EL PASO COUNTY, COLORADO GRANDVIEW RESERVE DISTRICT WTP WELL WATER COLLECTION

GENERAL
COVER SHEET

PCD #: PPR-24-30

CIVIL  
 SITE PLAN - CONSOLIDATED VIEW

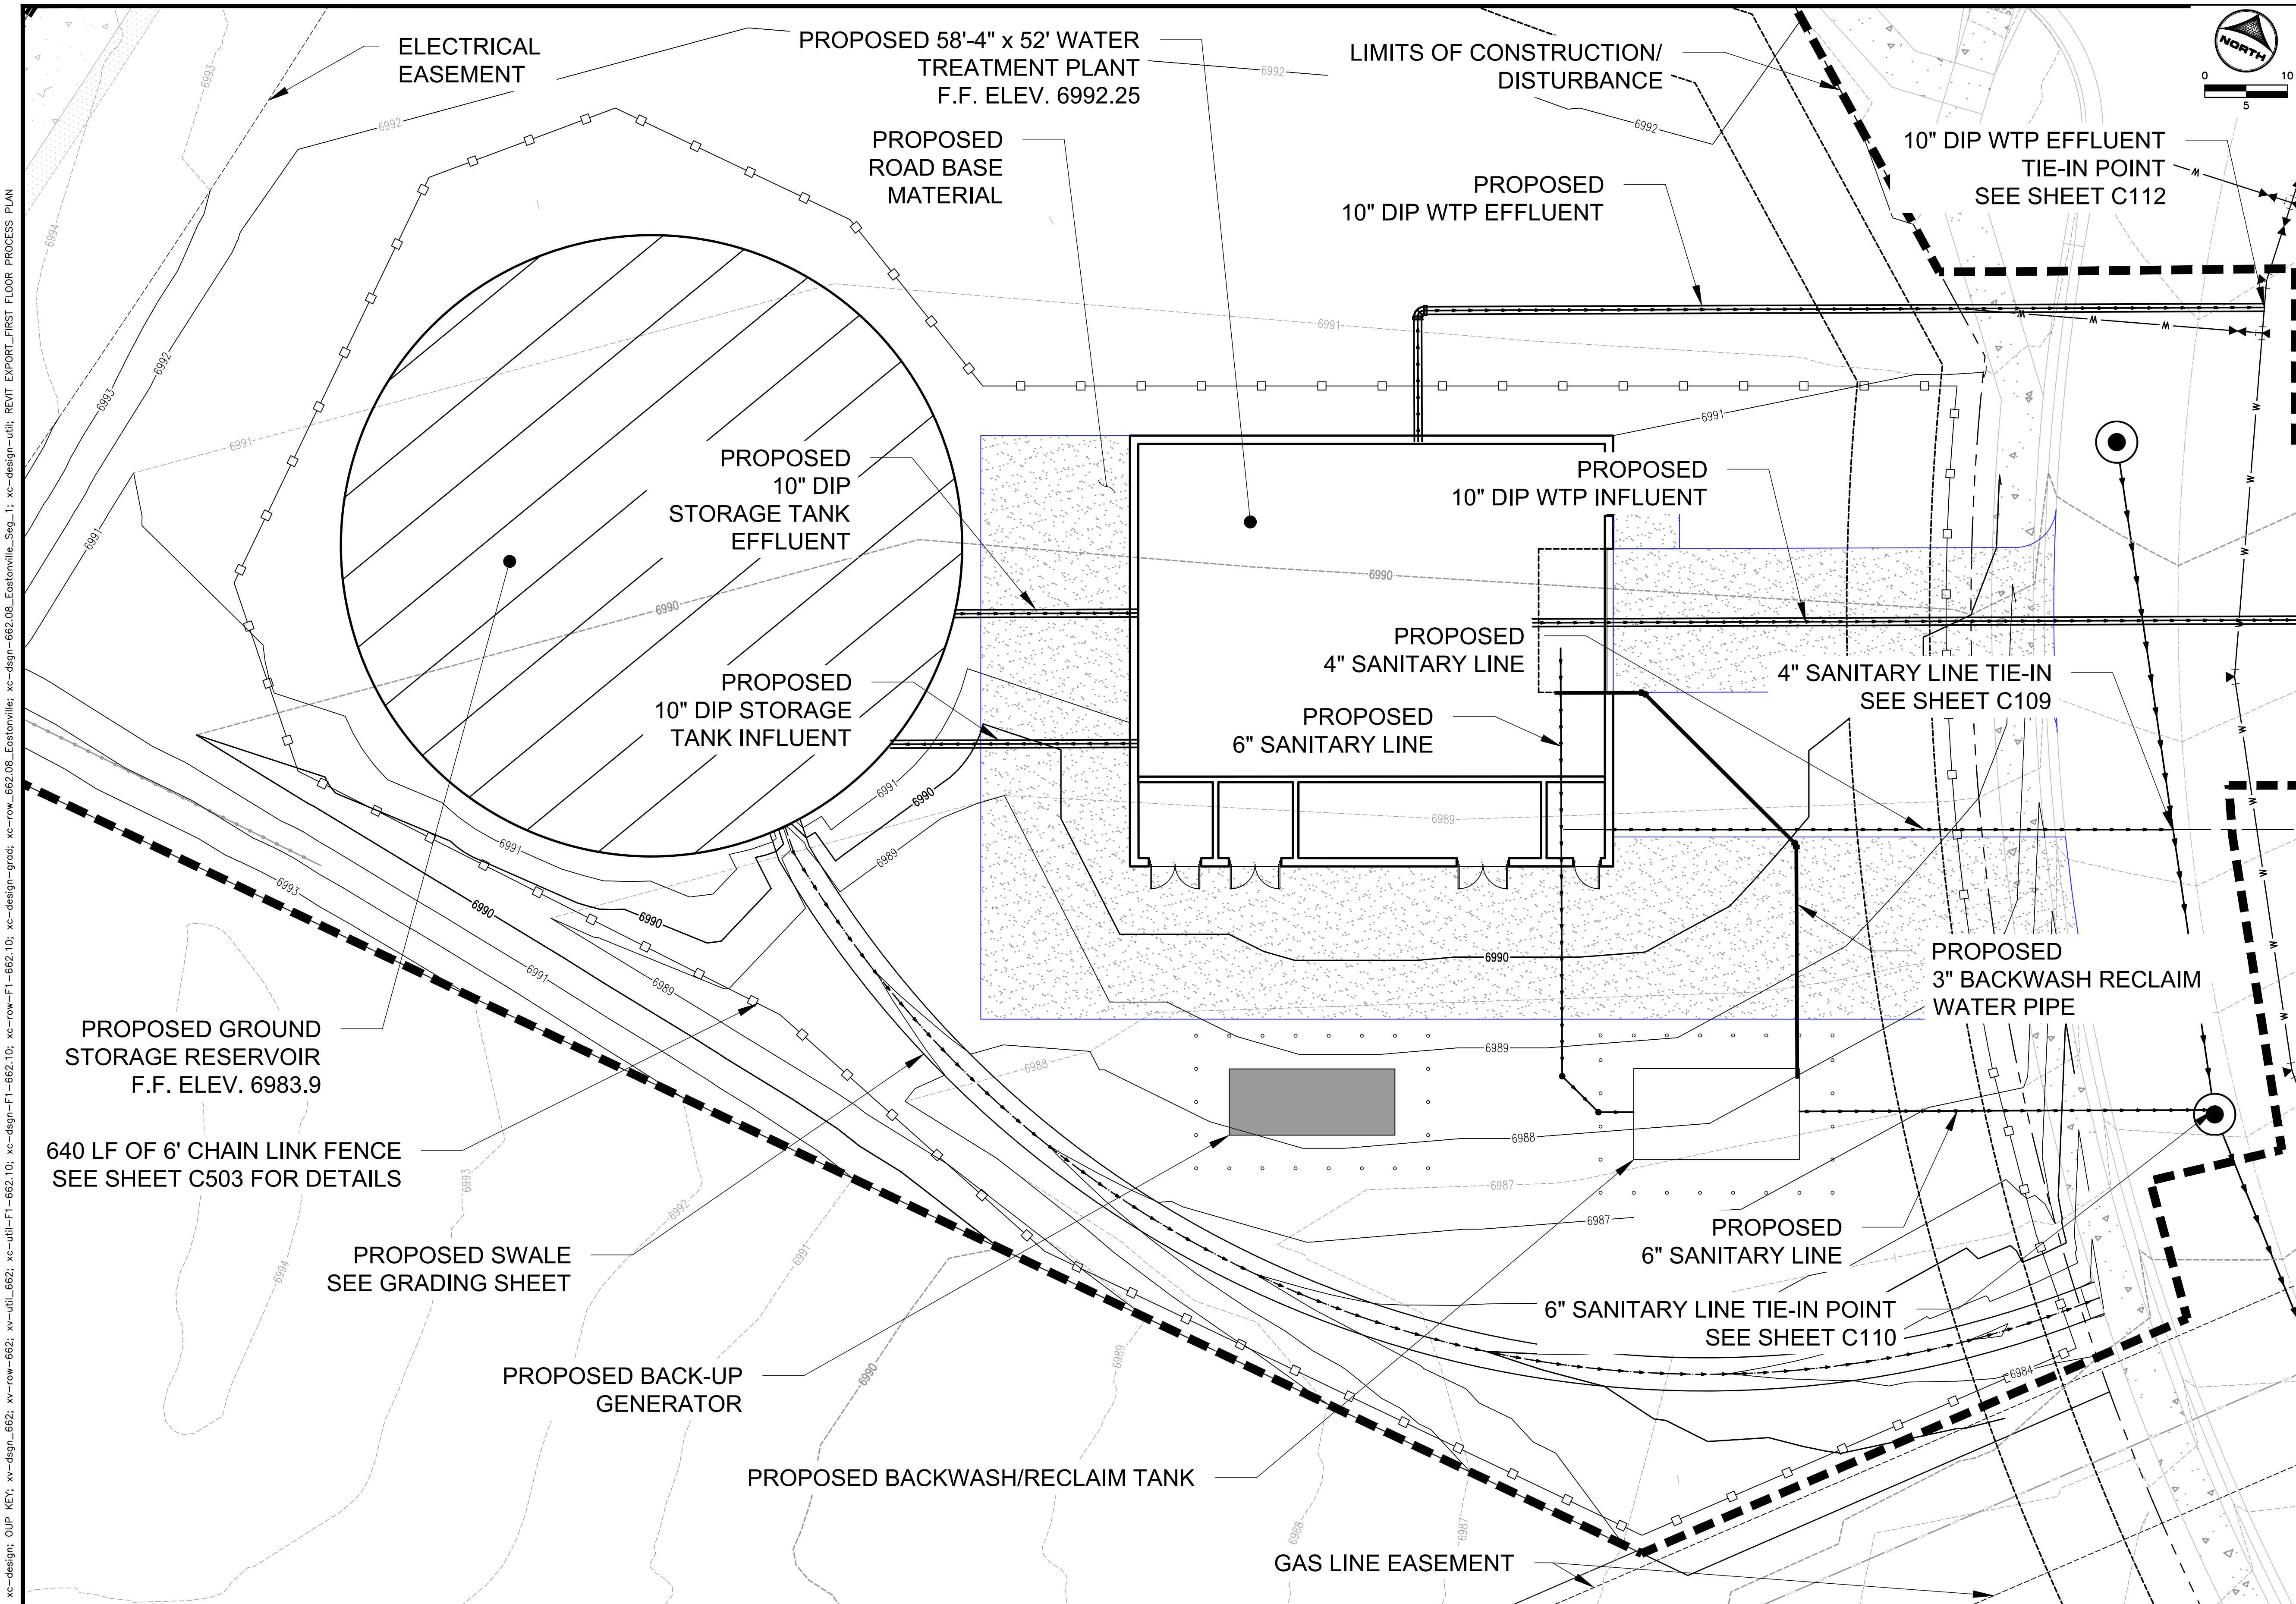
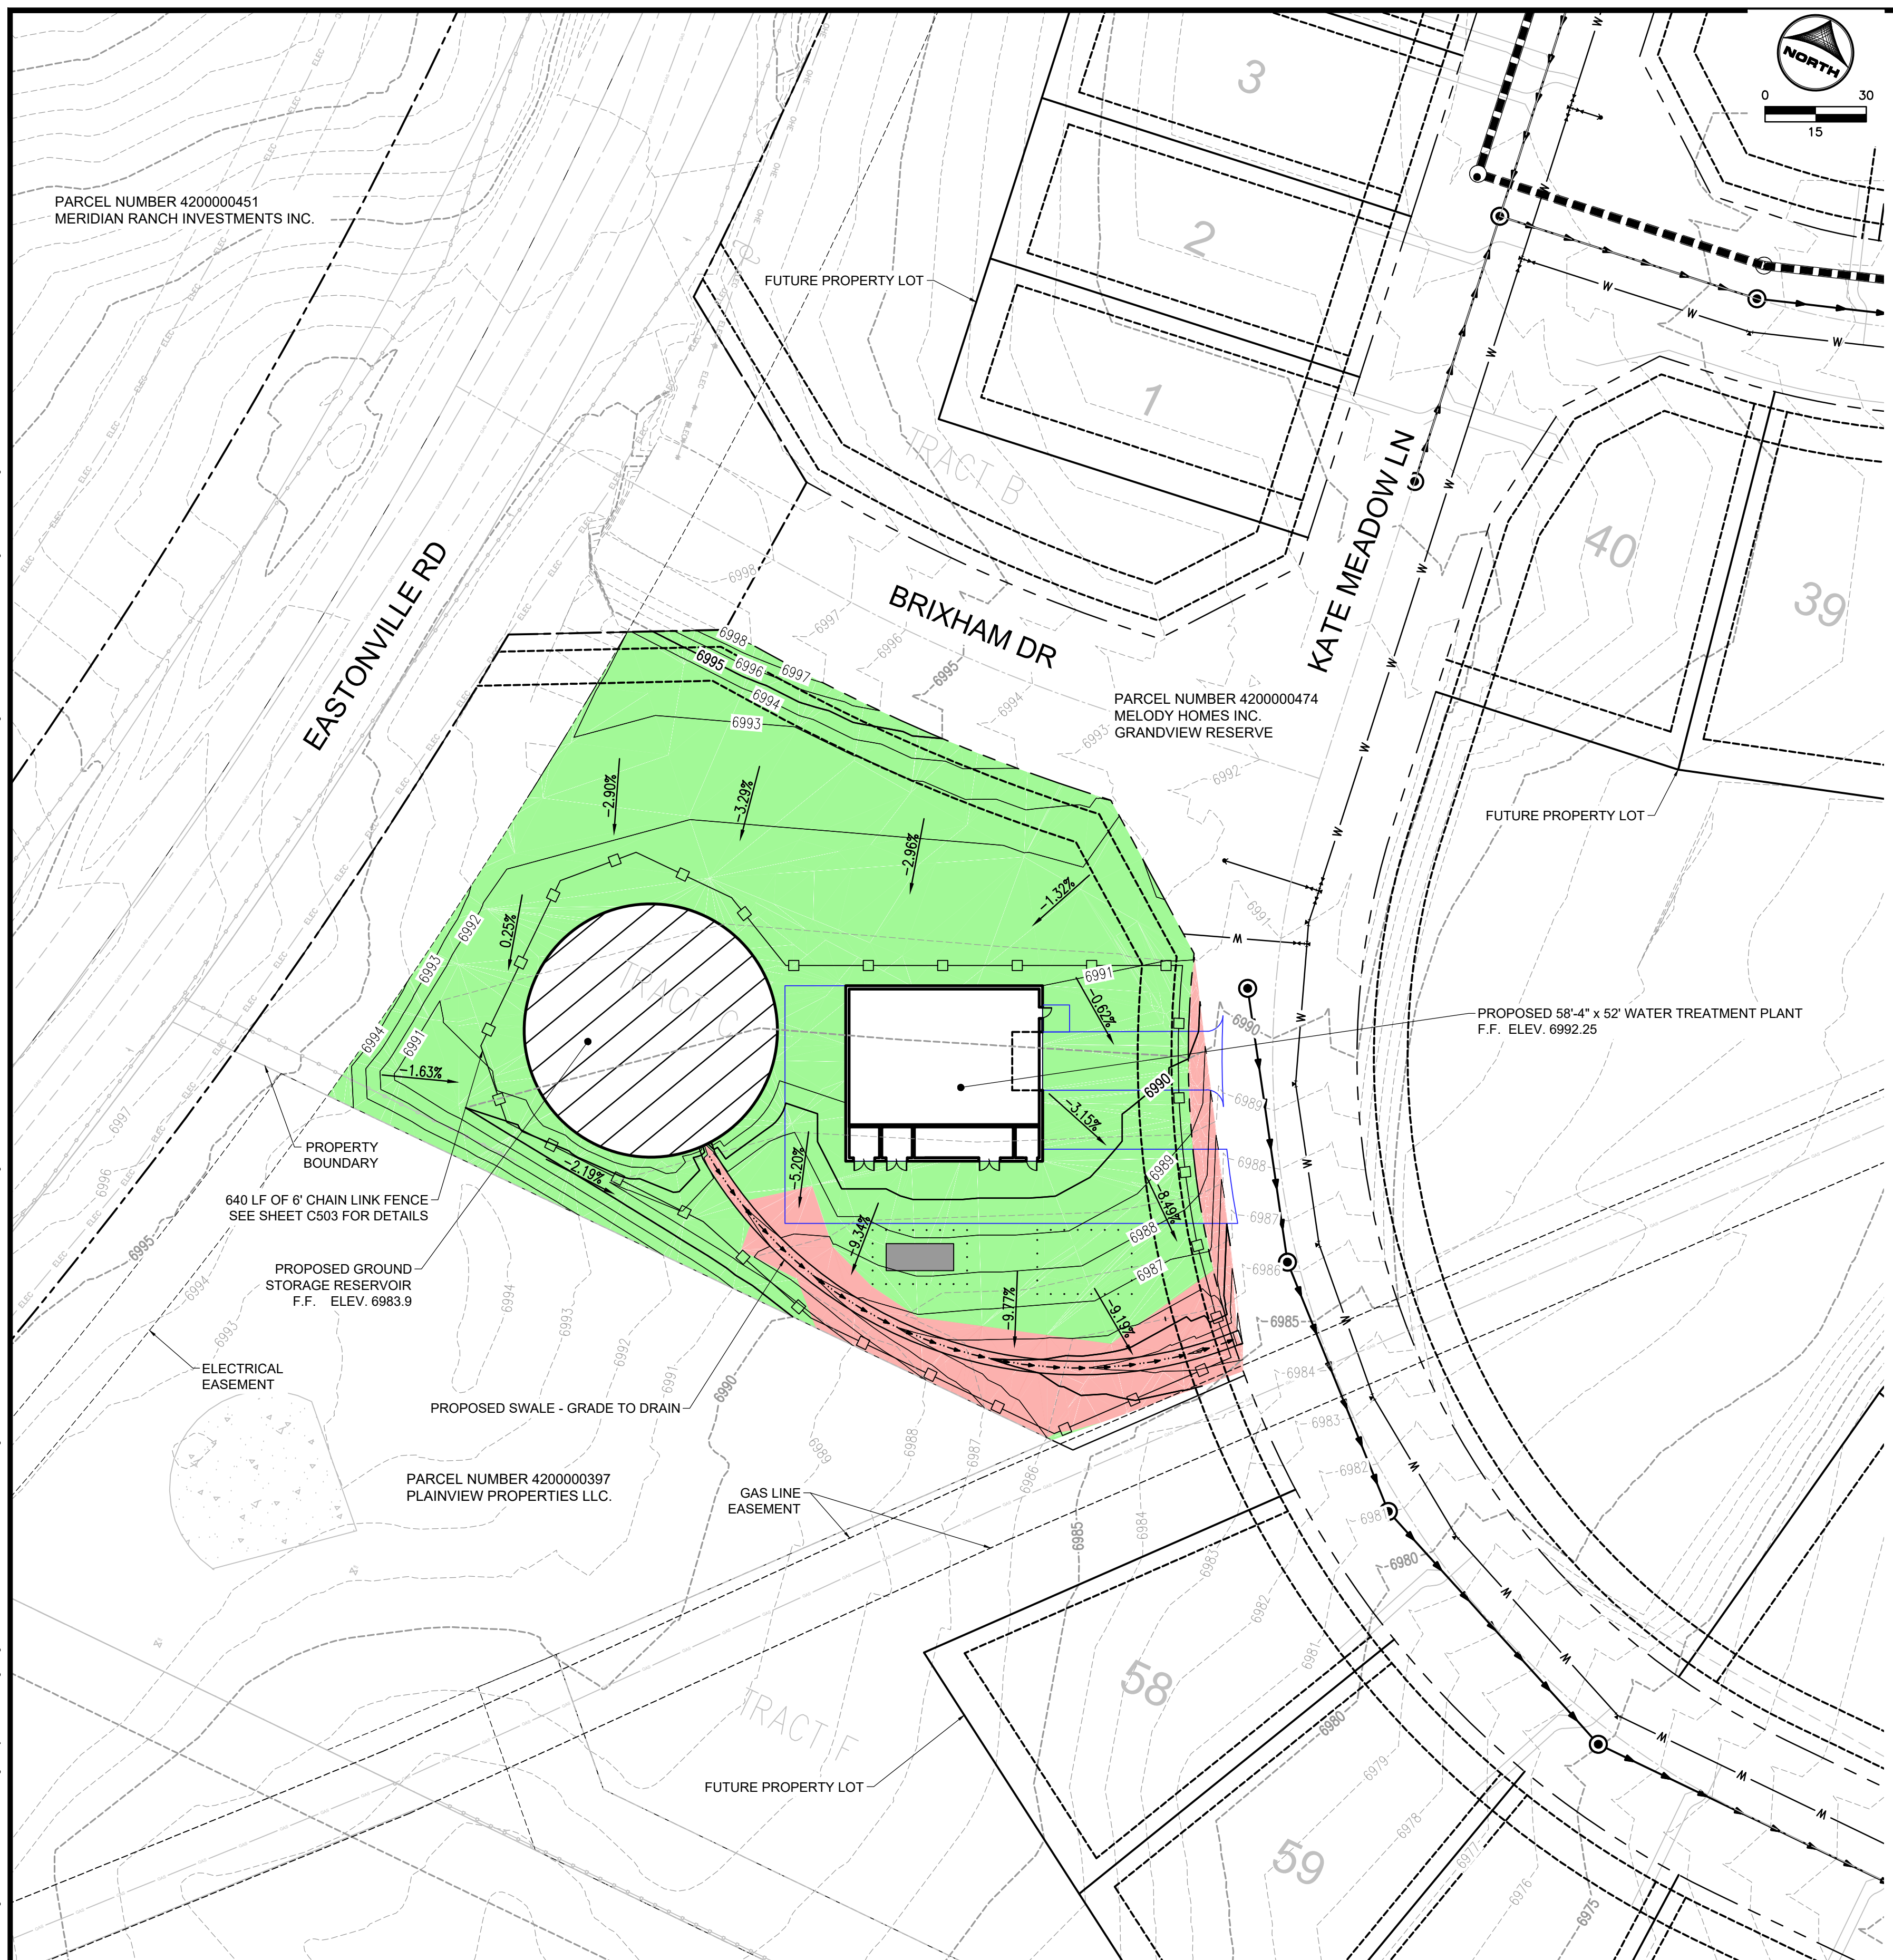
Provide location, acreage and legal descriptions of the water lines also. Answer should identify all the parcels or roadways the lines will cross over.

Sheet border is missing

CIVIL SITE GRADING PLAN

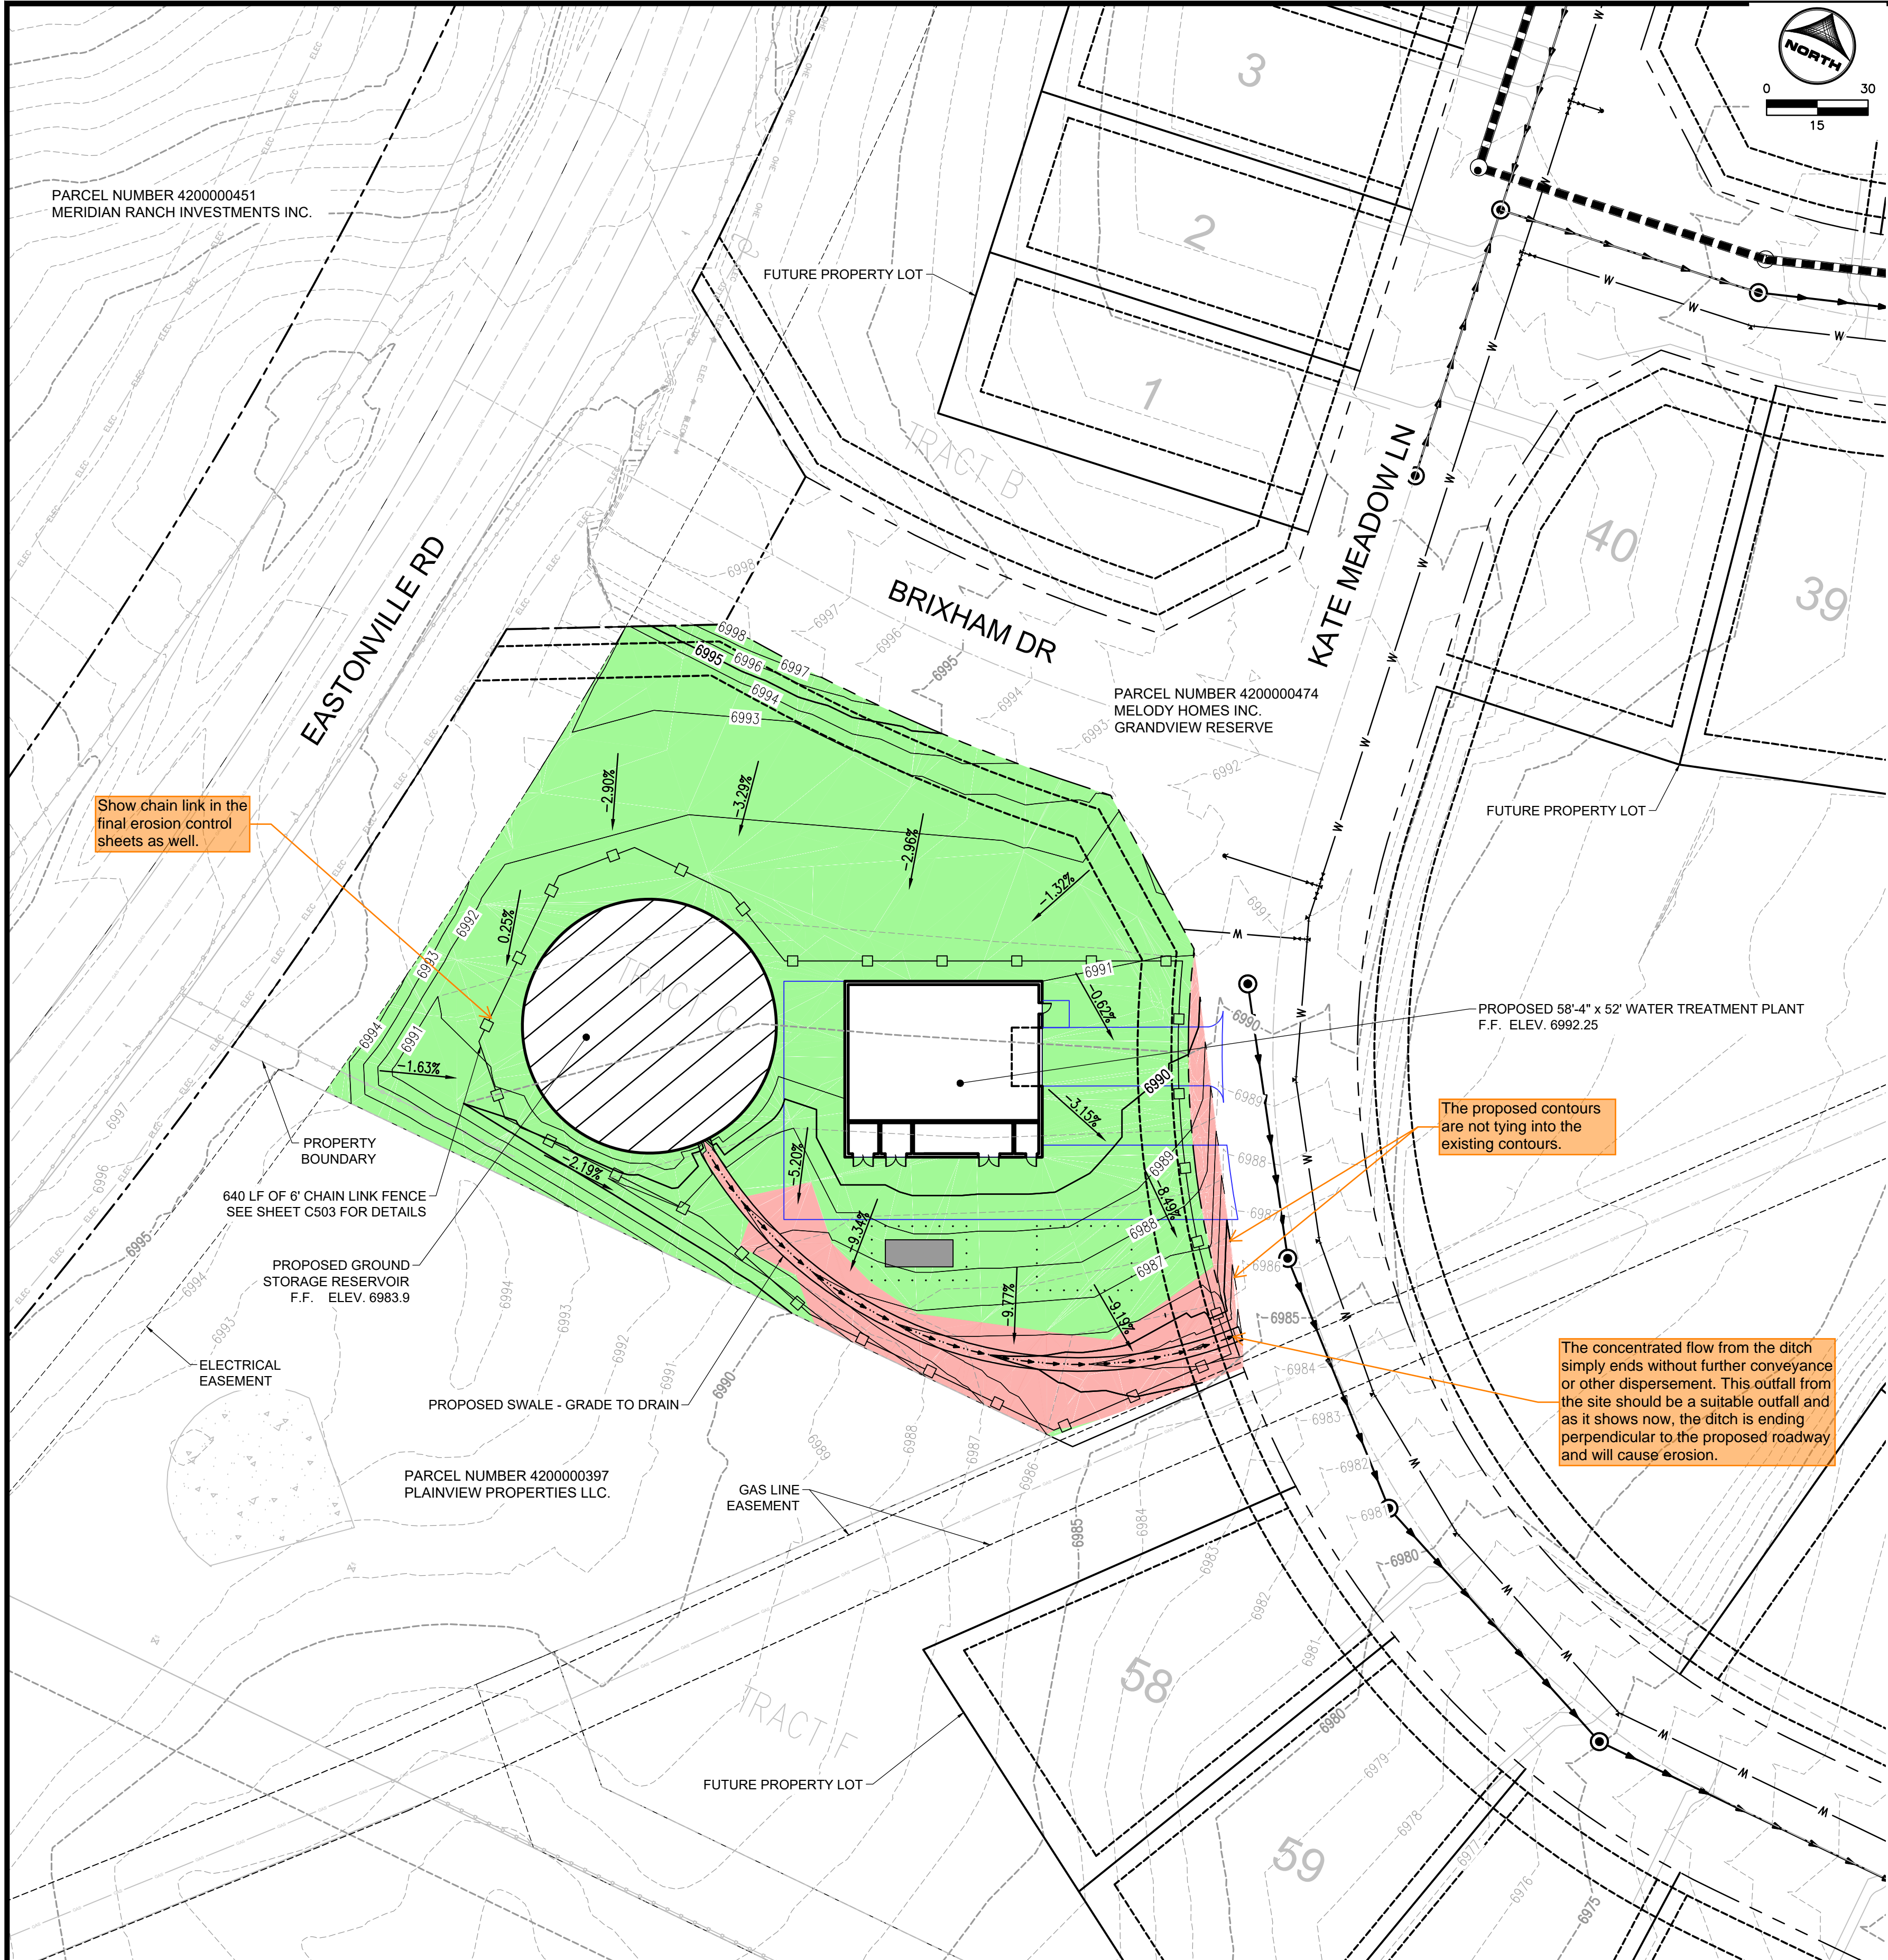
Please include:
-Zoning
-Parcel number
-Legal description
-Parcel size
-Lot area coverage calculation
-Existing/proposed land use and zoning
-Total gross building square footage
-Open space, landscaping, and impermeable surface percentage
-A note stating: The owner agrees on behalf of him/herself and any developer or builder successors and assignees that Subdivider and/or said successors and assigns shall be required to pay traffic impact fees in accordance with the El Paso County Road Impact Fee Program Resolution (Resolution No. 19-471), or any amendments thereto, at or prior to the time of building permit submittals. The fee obligation, if not paid at final plat recording, shall be documented on all sales documents and on plat notes to ensure that a title search would find the fee obligation before sale of the property.
-Parking computations
